**From:** Contact Centre (CRM) <contact@ribblevalley.gov.uk>  
**Sent:** 12 October 2021 10:01  
**To:** Web Development; Planning  
**Subject:** Planning Application Comments - 3/2021/0898

Proposal: Proposed raised roof to dormer bungalow to create full two storey dwelling and alteration to parking arrangements. Resubmission of 3/2021/0237

Location: 3 Moor Field, Whalley, BB7 9SA

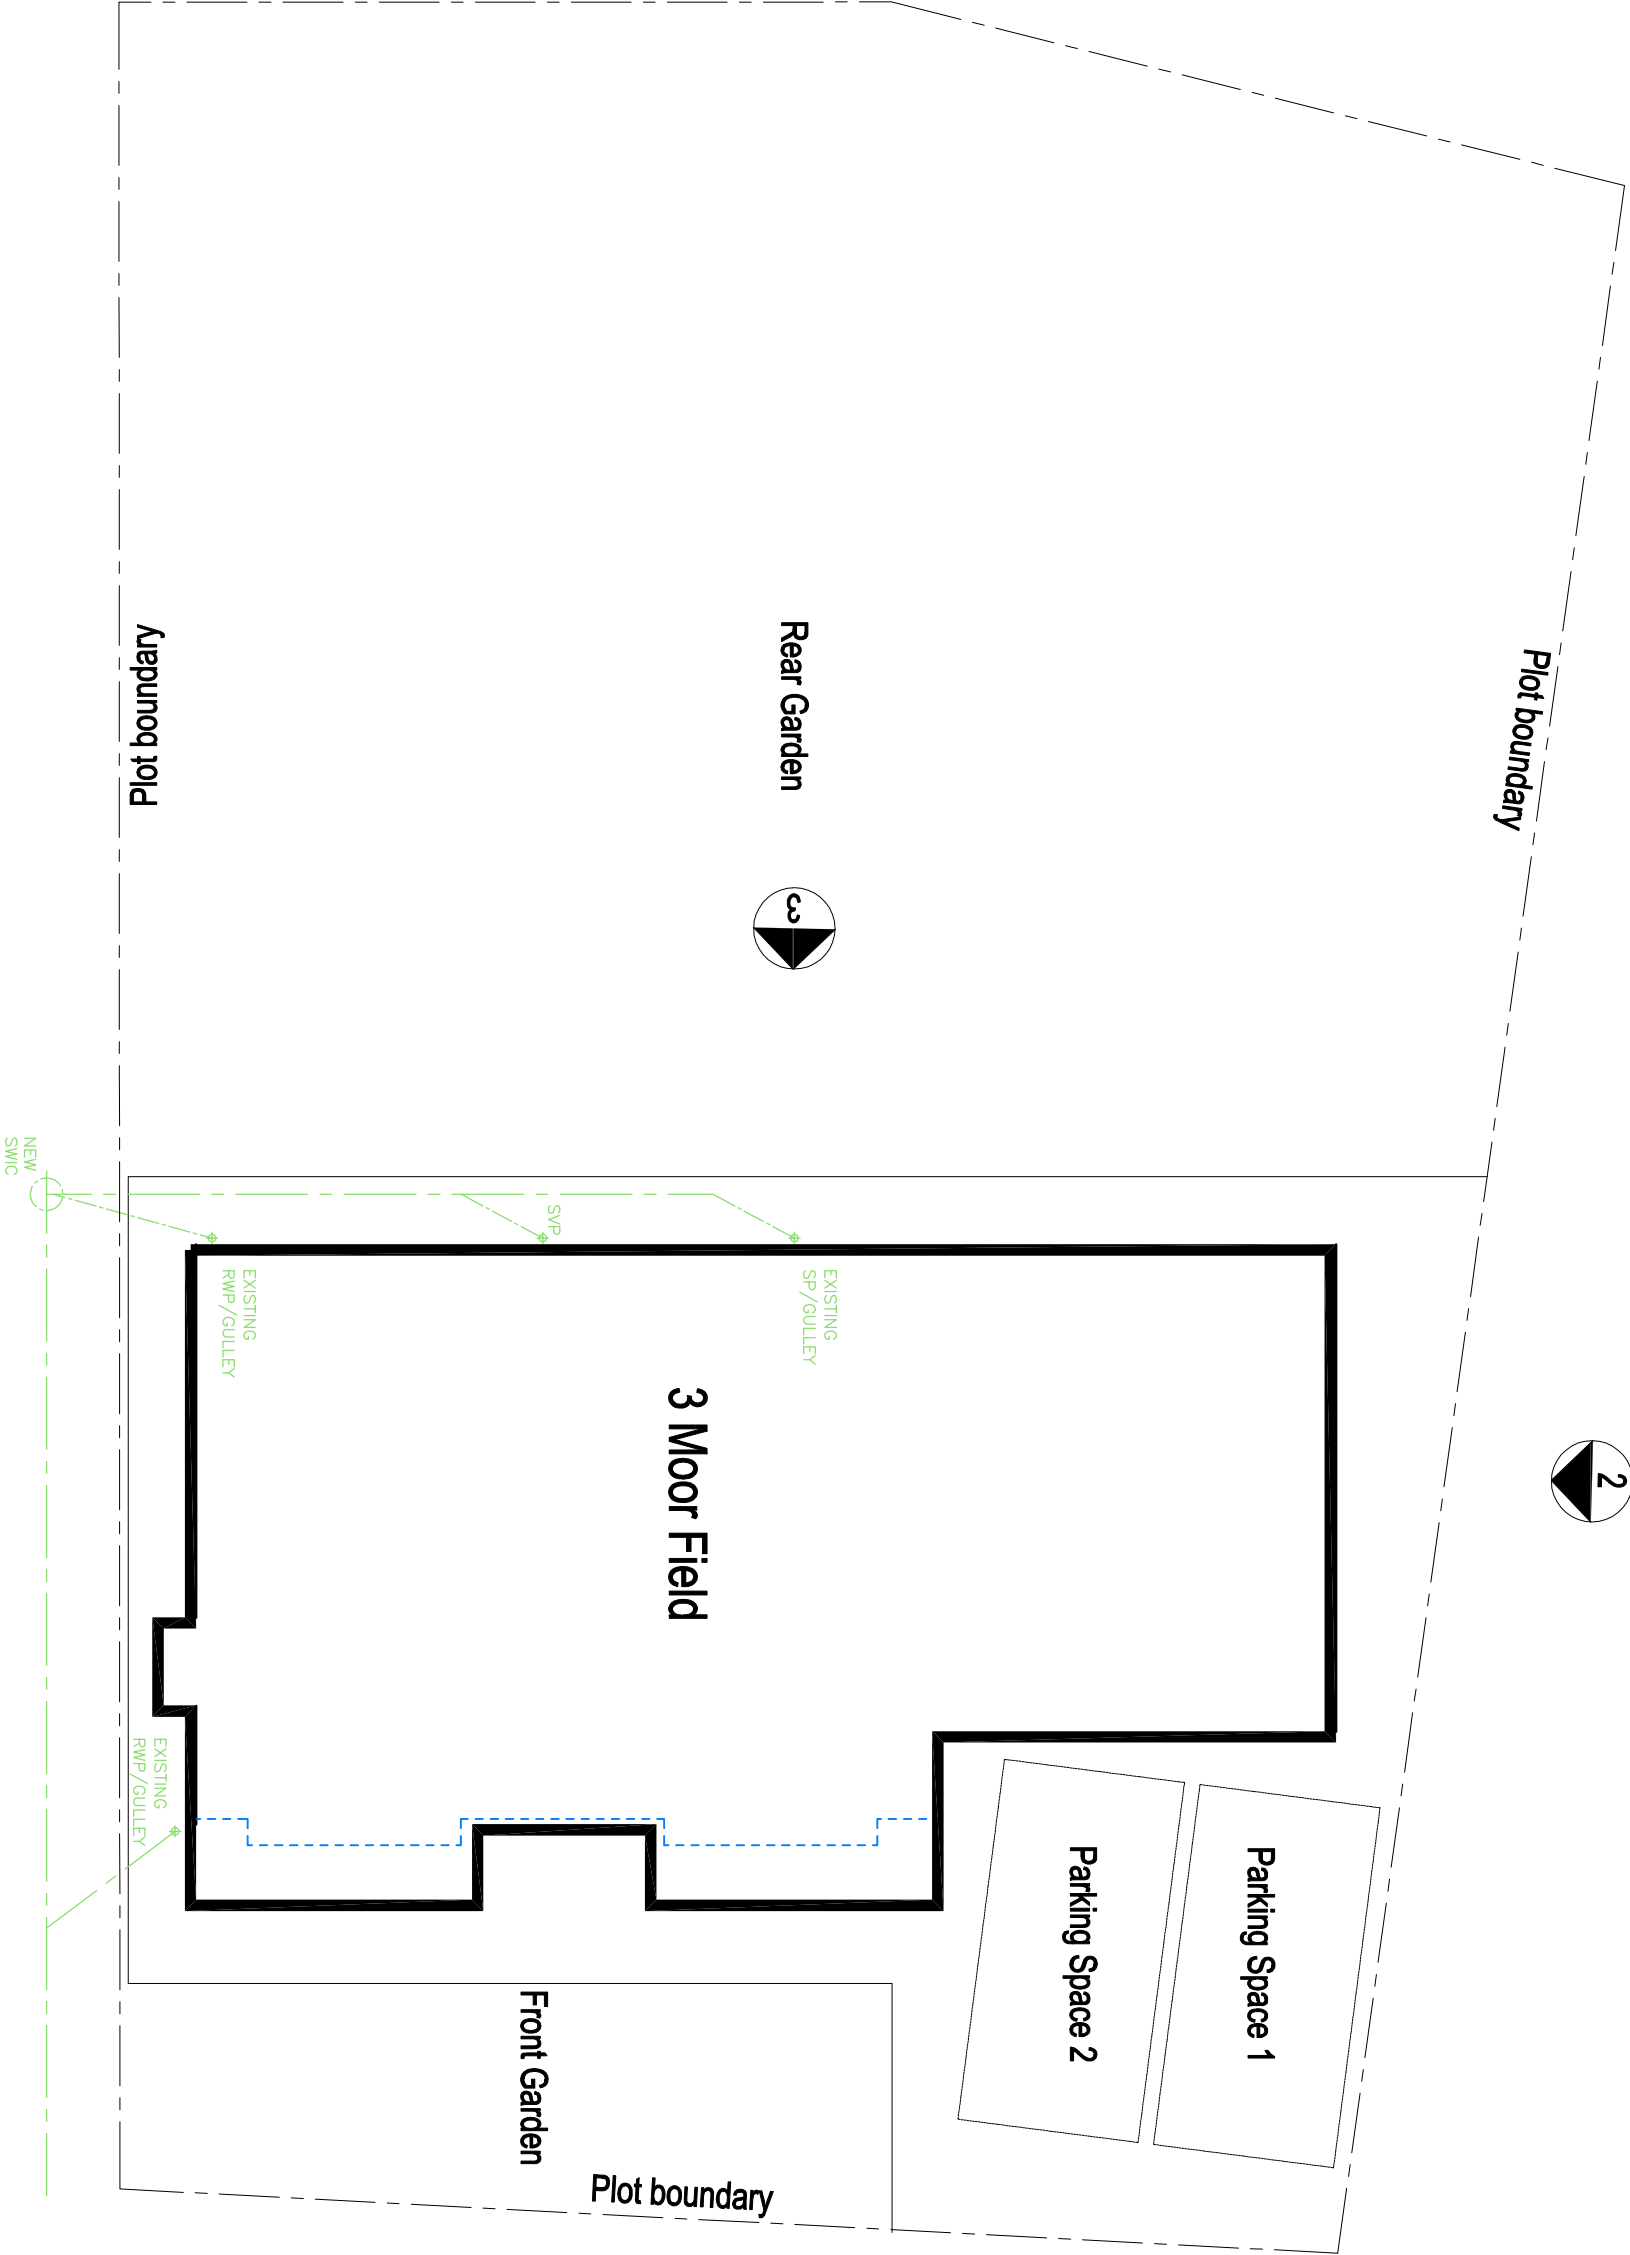
Finally, from the diagrams it would seem that this resubmitted proposal is actually trying to come forward from the previous "building line" and is out of synch with the other properties. A needless "land grab"?

This new scheme is in all respects very similar to the original scheme, now with increased two storey footprint to the front elevation bringing this building profile out by a metre. The raised roof in the new scheme( albeit not as high as the original) and this increased footprint, plus additional development to the rear, introducing windows and projected rooflines to a second storey which push the upper floor profile to the roof edge, is creating an incongruous building which dominates the existing frontage and street scene and is unacceptable.

It appears from the architects' drawings that there is a forward projection to the front of the building, either side of the front door. The extent of this projection is not defined clearly by measurements. However, it does appear to be beyond the existing footprint of the building. Is this allowed?

PROPOSED STREET SCENE

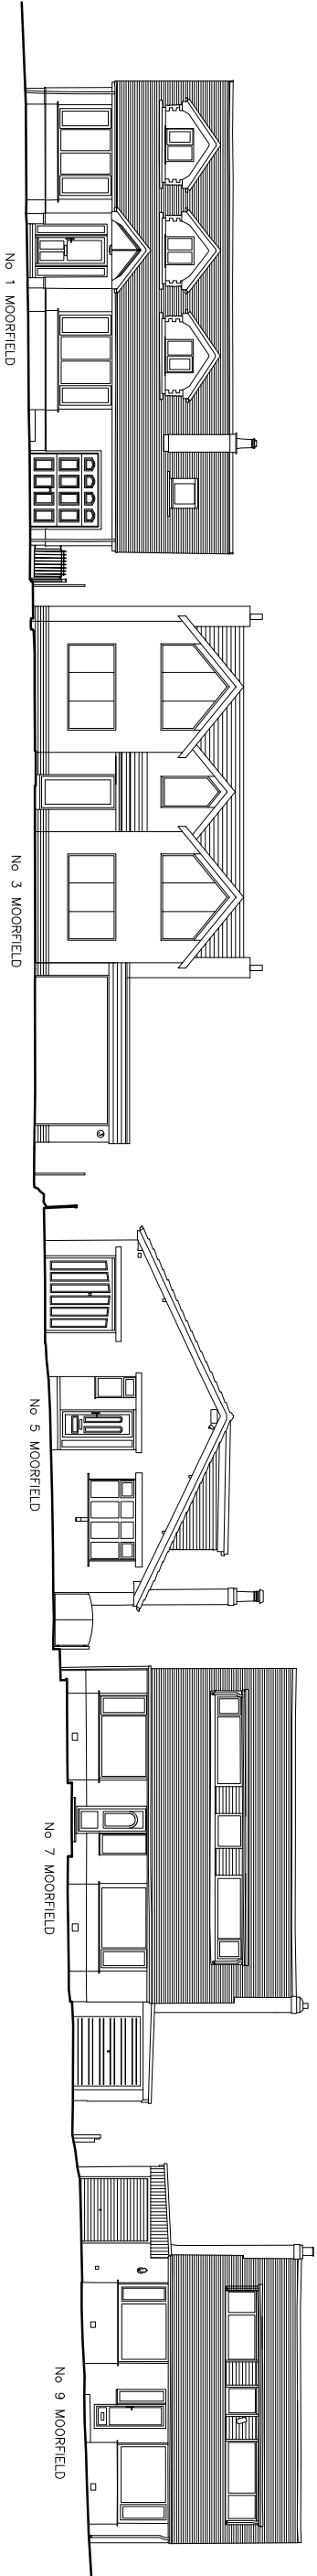
I would point to the words above 'Simple' roofs and dormer extensions. This new proposal whilst reducing the height of the second story is not in keeping with the surrounding properties. This is a significant change to the property which still impacts the street scene which is characterised by properties with single storey elevations, predominantly steep roof pitches and repeating similar front dormer features, again using words from the appeal decision.

At a minimum the front elevation needs to be in keeping and sympathetic to the surrounding properties.

The proposed elevations and gable will be completely out of character with this estate and dominate the houses on either side and opposite the view of which would appear as an imposing box. The aspect looking up and down the street will be impacted by what is in effect still a proposal for an incongruous two storey house (badged up as a dormer bungalow which it clearly isn't). We have no objection per se to neighbours improving the estate and their homes, however, this should be done sympathetically and in keeping with the surroundings – this proposal does not suit this established estate.

Furthermore, the appearance is still that of a two-storey dwelling (a house) which within the street scene depicted stands out alone and is surrounded by true dormer bungalows.
